WILLOUGHBY CITY COUNCIL

SUBMISSION

COMMENTS ON APPLICATION FOR MODIFICATION 6 TO MP09_0066 – THOMAS STREET CAR PARK SITE DEVELOPMENT

APPLICANT: MERITON GROUP

1 ELEVATION – SOUTH
1:250

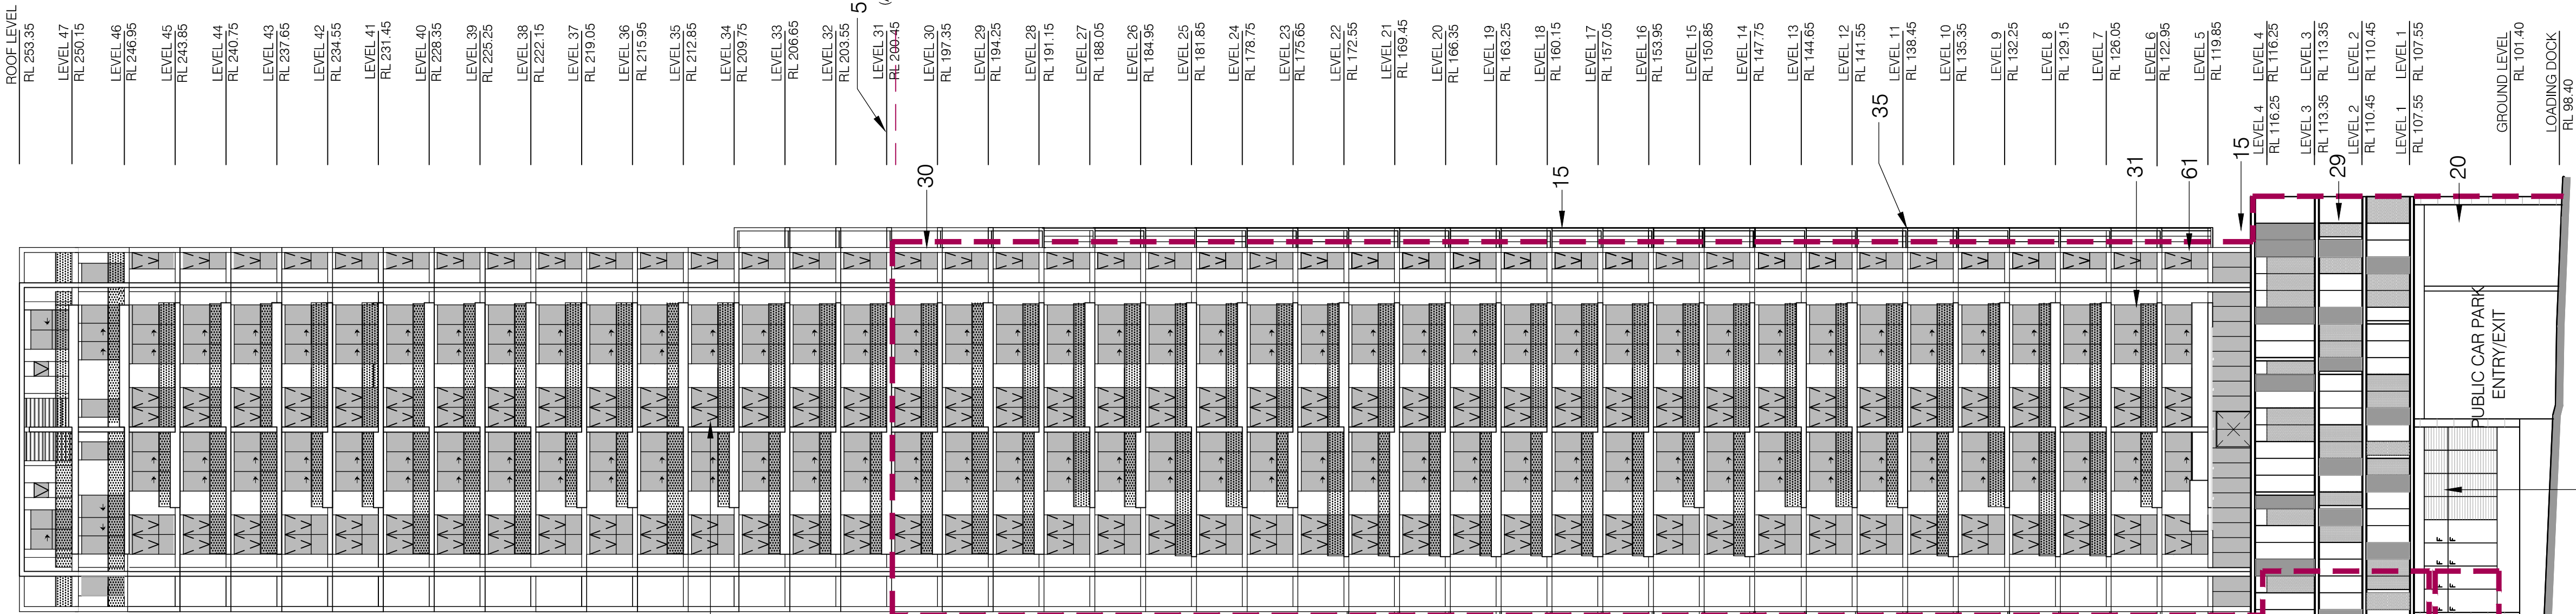
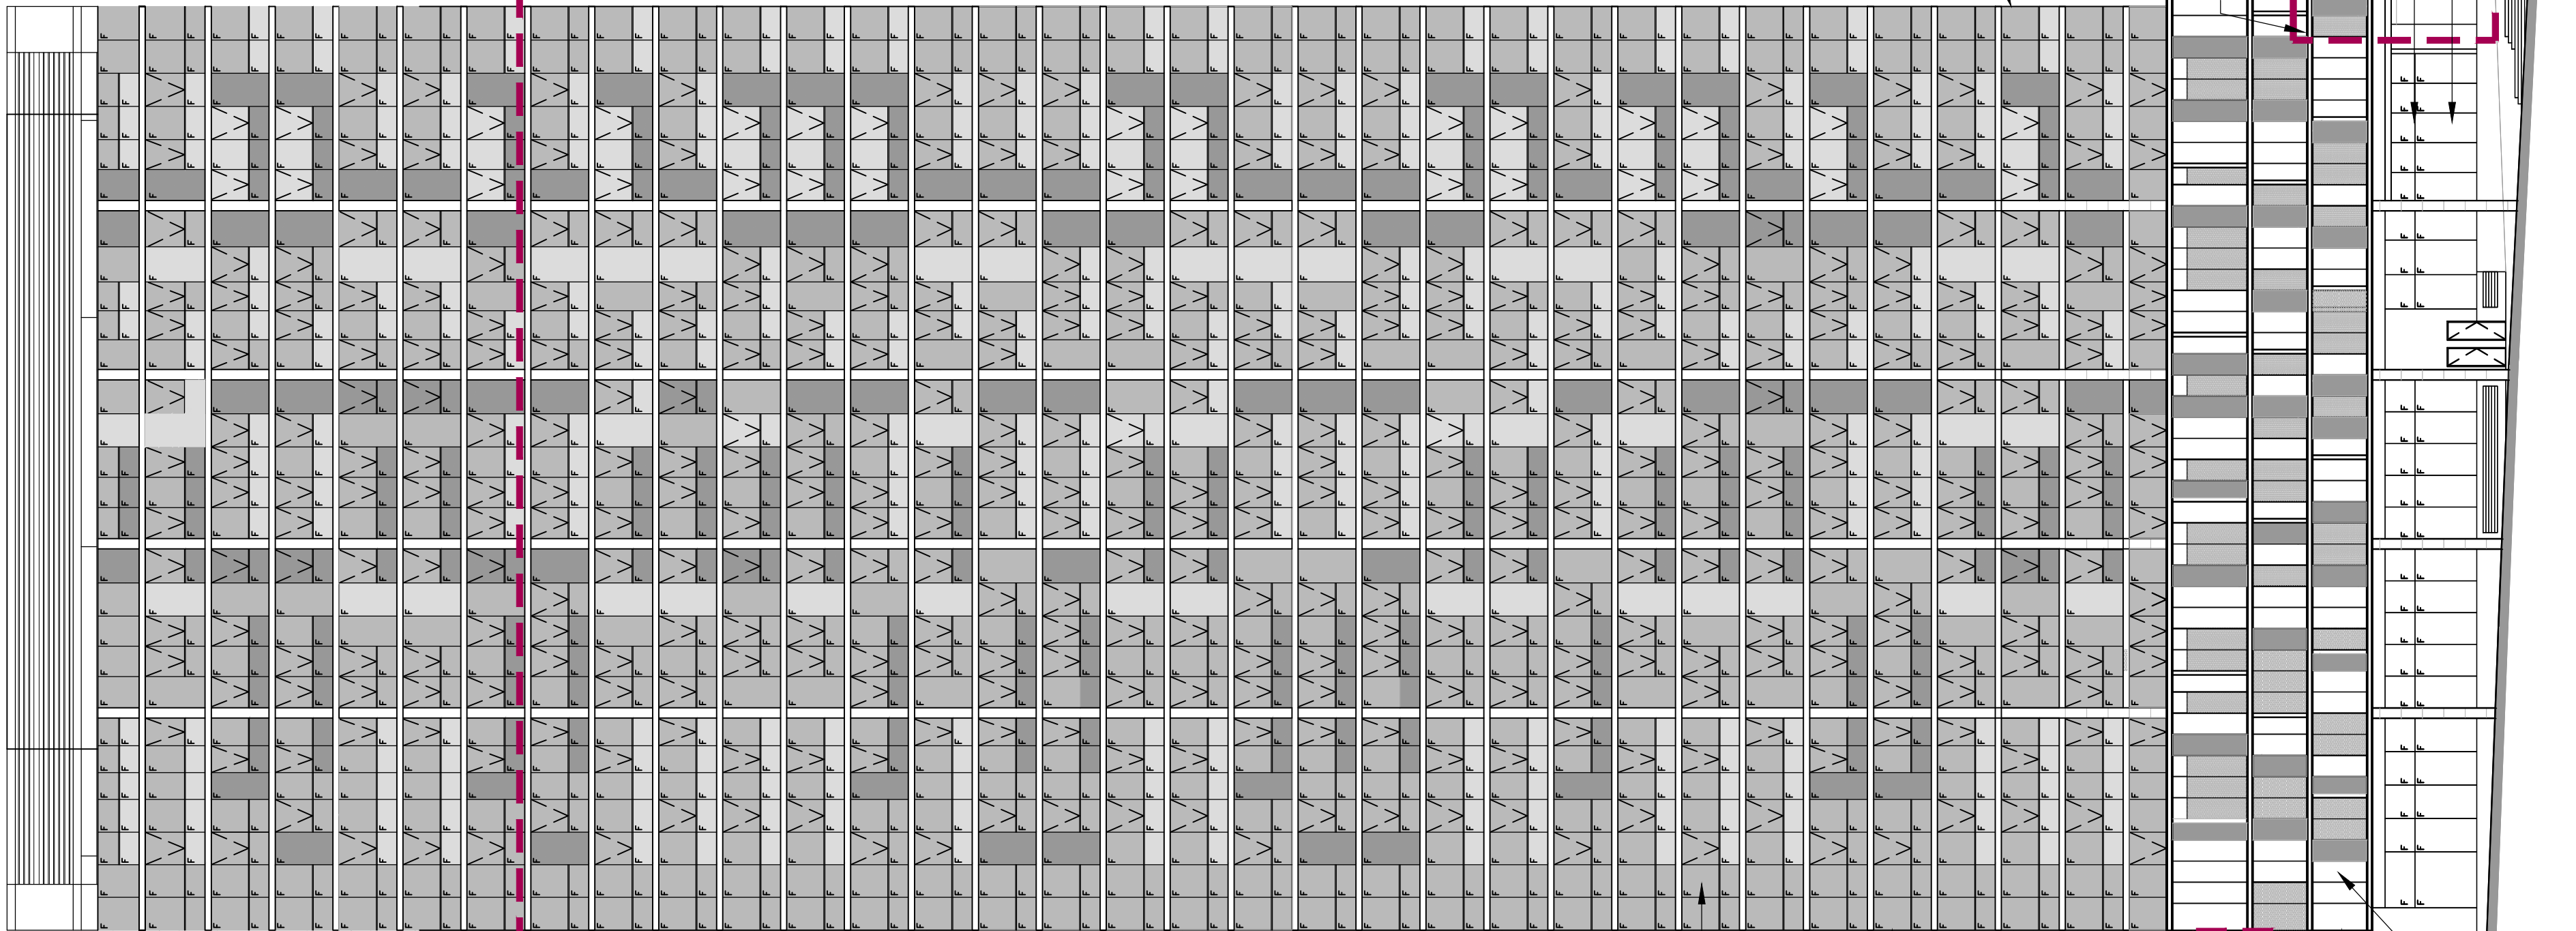
- 3.5 The mass and bulk of the towers with the increase in height will be visually prominent on the southern edge of Chatswood CBD. They will dominate the southern approach to Chatswood in a scale that is inconsistent with the surrounds and site context. External finishes currently proposed include painted finishes that have ongoing maintenance concerns in for buildings of this scale. The schedule of finishes should be revised to limit painted finishes to minor external elements with predominant use of pre-cast or pre-applied finishes. In order to maintain a high standard of finish and continue the design quality throughout construction, Council recommends that a condition be imposed requiring that the design architects oversee the quality of finishes and façade treatment throughout construction, This could be concluded with a design certification prior to occupation certificate that the completed building conforms to the intended design standard as presented in the application drawings and perspectives.

BUILDING 1
ELEVATION - EAST
A-0123
D
SECTION 75 W MODIFICATION 6

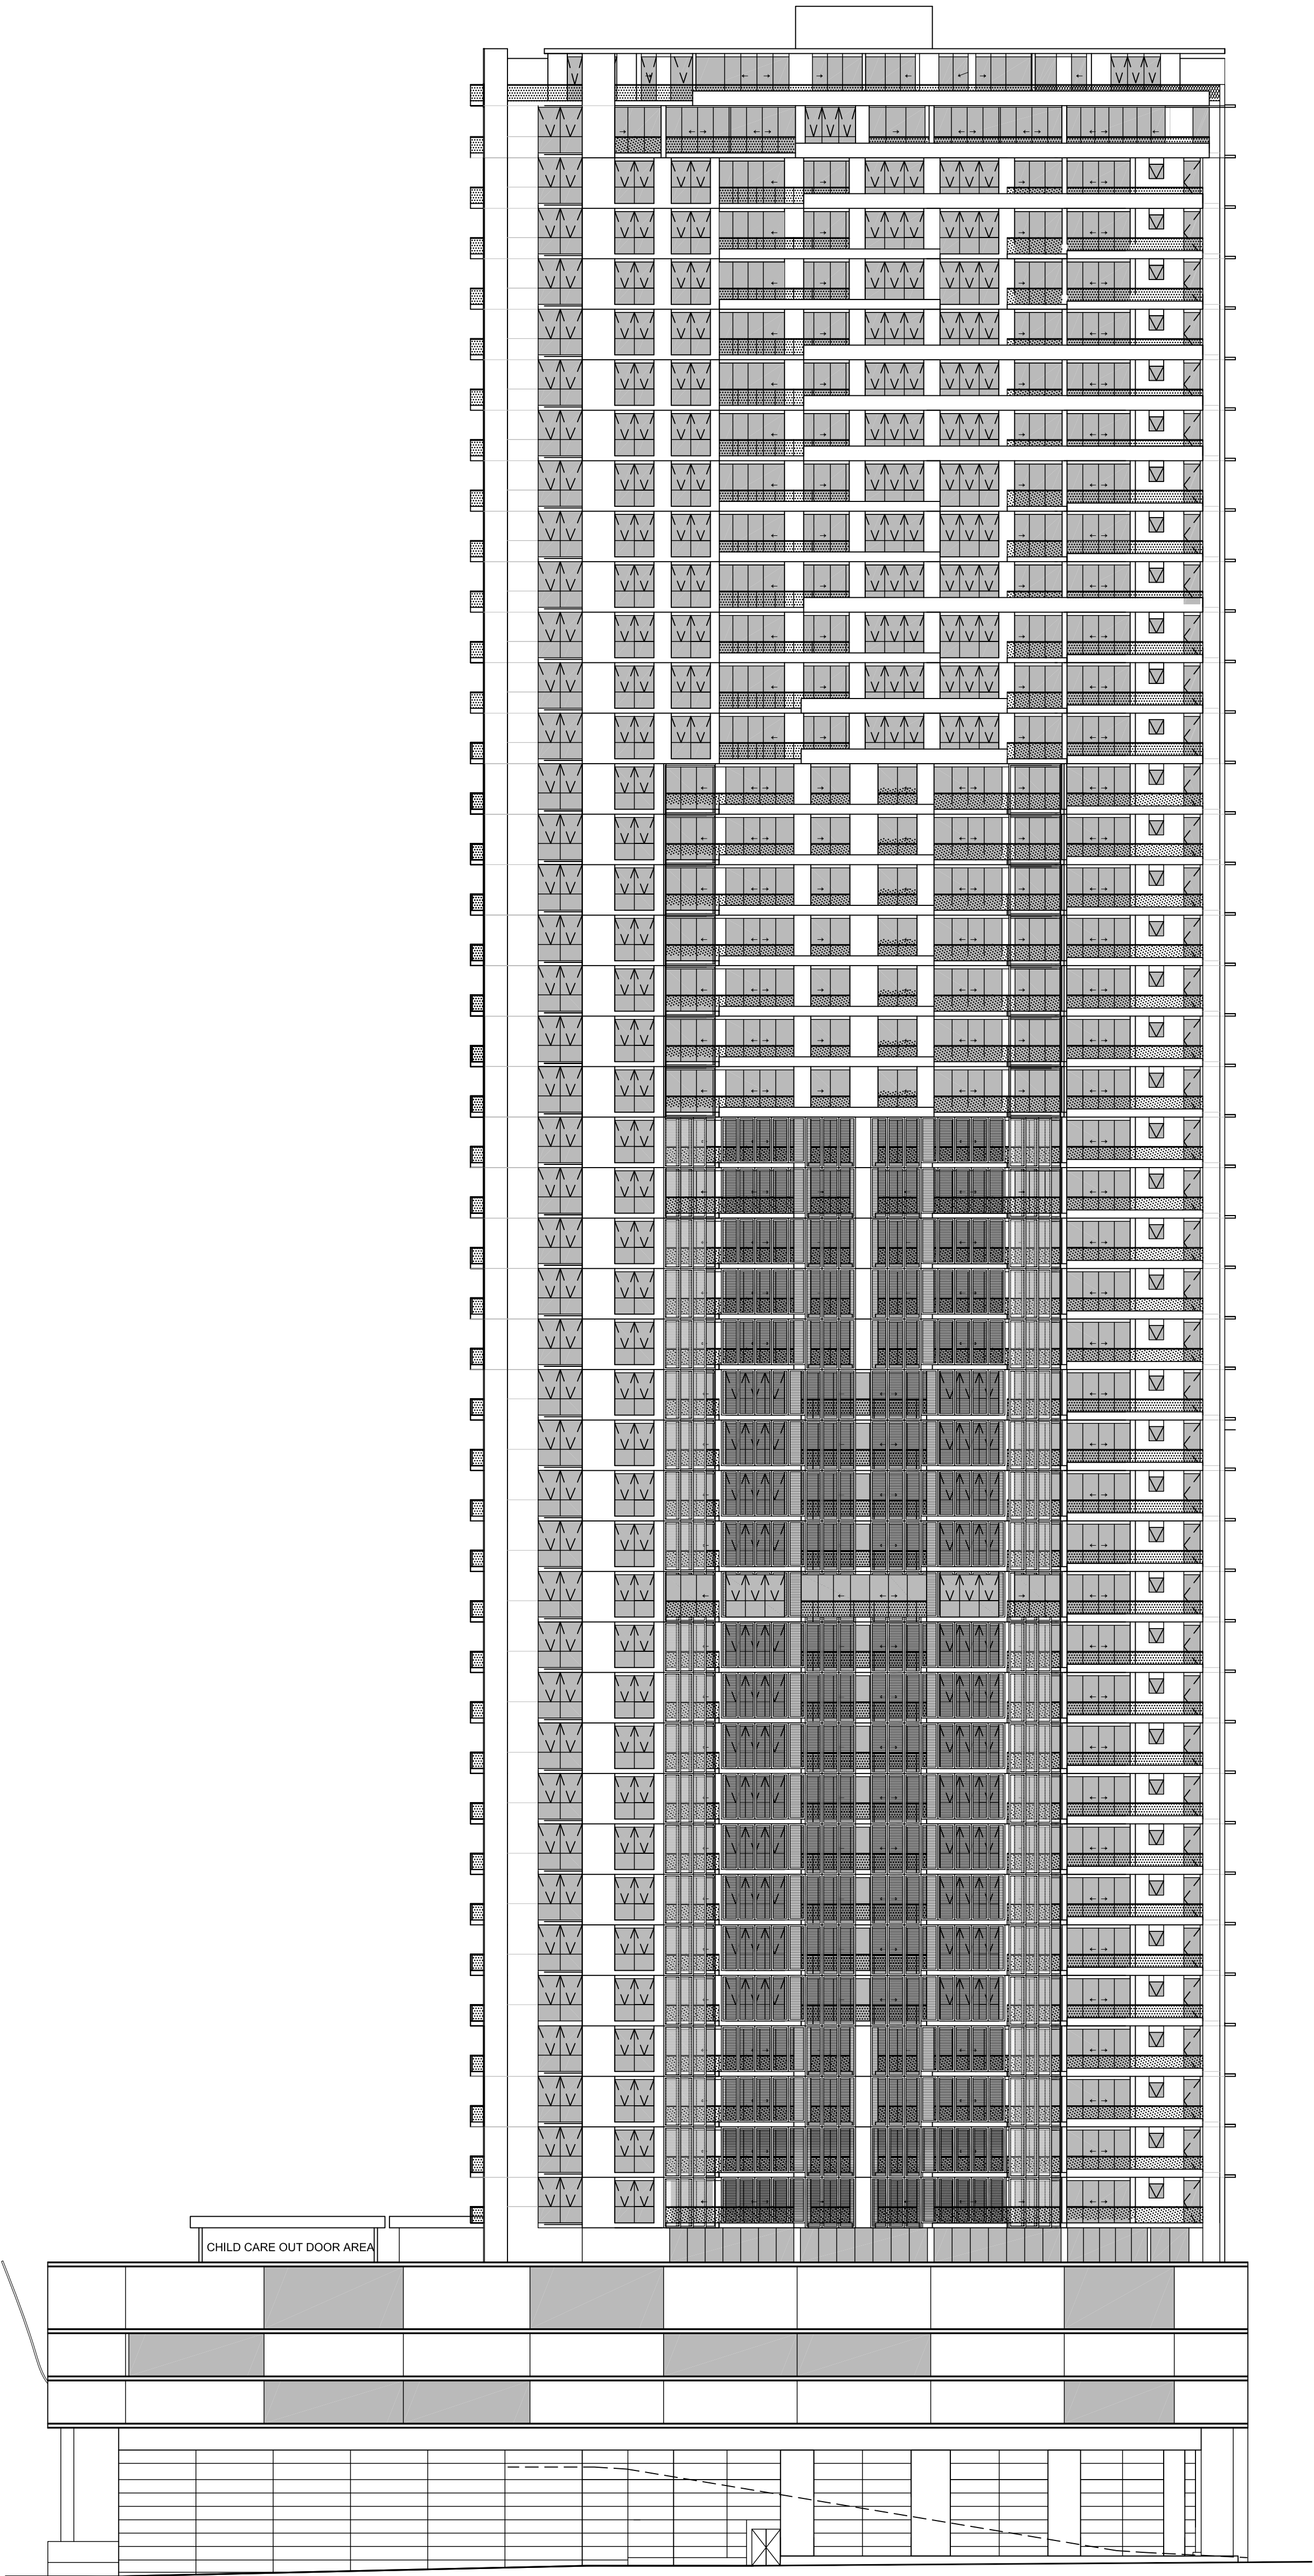
The proponent's justification for the increase in height and floor space is based on the Chatswood Interchange Towers. The towers have a maximum roof height of the tallest of the 3 towers (Tower 1) of RL 239.6 (not RL 263.8). The height of the plant room of Tower 1 is RL 246.8 and the height of RL 263.8 is the top of the architectural blade roof feature not usable floor area. The height of the residential tower on Modification 6 is RL 253.35.

The Cross Site link

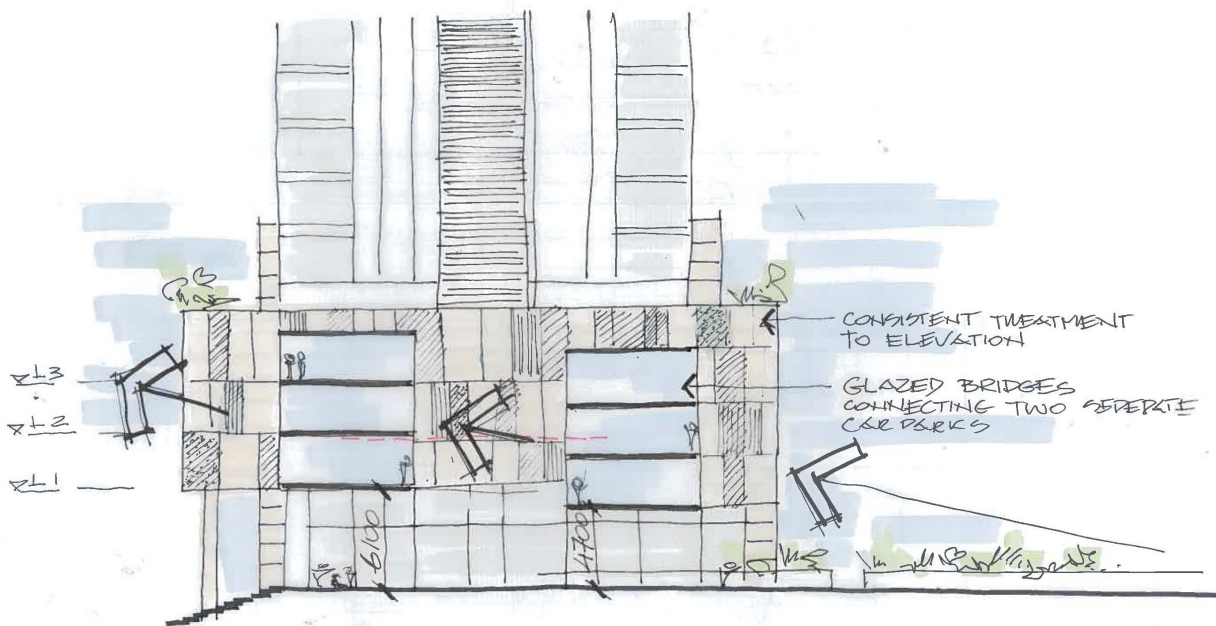
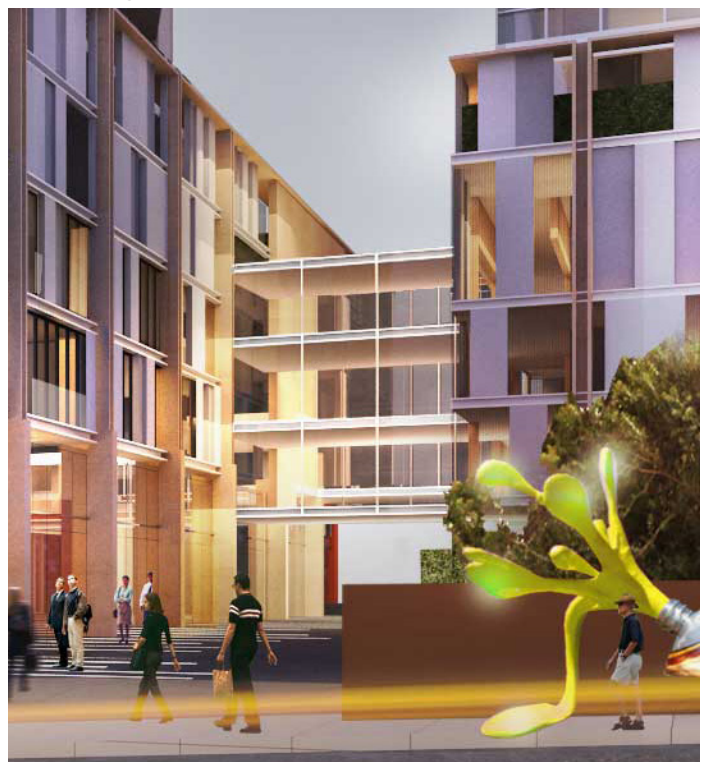
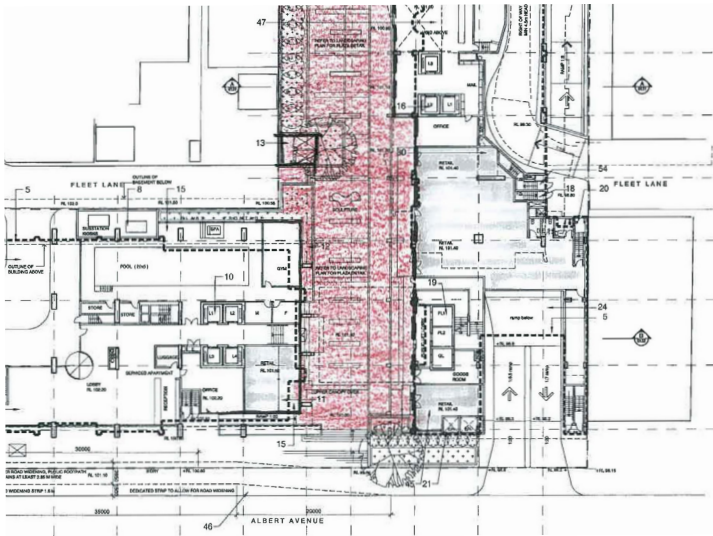
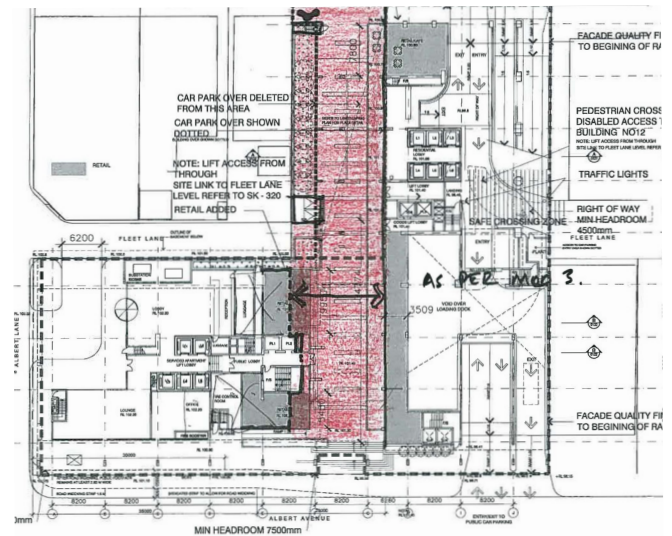
- 3.2 The landscaped open space plaza was fundamental to the site specific planning of the site to enjoy the penetration of northern sun achievable along the alignment of Katherine Street. This is compromised with the modification plans as it will be enclosed by the proposed above ground parking and will become a “gun-barrel” walkway. Its area has been significantly reduced in size making it no longer a usable recreational space as well as a through site link. The retail/active frontage is tokenistic and questionable in its viability to provide an active frontage along the link. The proponent has suggested that the space could be used for art exhibitions or similar. In the absence of details in respect to management of such a space, the curatorial requirements for exhibitions and how the space will be controlled within the site, it is most likely that the narrow retail “strip” or exhibition space will be unviable. There will not be the throughput of pedestrians to make such retail space successful. Council would propose that the windows to the space be removed and it be added to the landscaped open space with public seating or additional garden space.

The proposed walkway and ceiling treatment will require 24 hour lighting that is energy inefficient.
- 3.3 The mass and bulk of the boundary to boundary podium of above ground car parking as proposed in the Modification will have an adverse visual impact on the streetscape of Albert Avenue. It is preferable that car parking should be provided in below ground basements. The detail of the proposed façade treatment and finish is inadequate. The use of external finishes that have a short maintenance life such as painted surfaces is inappropriate for this CBD location. The mass and bulk of the podium will still dominate the streetscape in Thomas Street and in Albert Avenue. The podium will become even more prominent when the road widening occurs on the northern side of the intersection of Albert Avenue with Pacific Highway and when the building on 763 Pacific Highway is demolished at some time in the future for redevelopment. Moreover the site is also affected by RMS road widening along its frontage to Albert Avenue such that the podium will be a dominate element over the road footpath. The adequacy of the clearance above the surface of the road footpath where the road widening is to occur needs to be clarified.
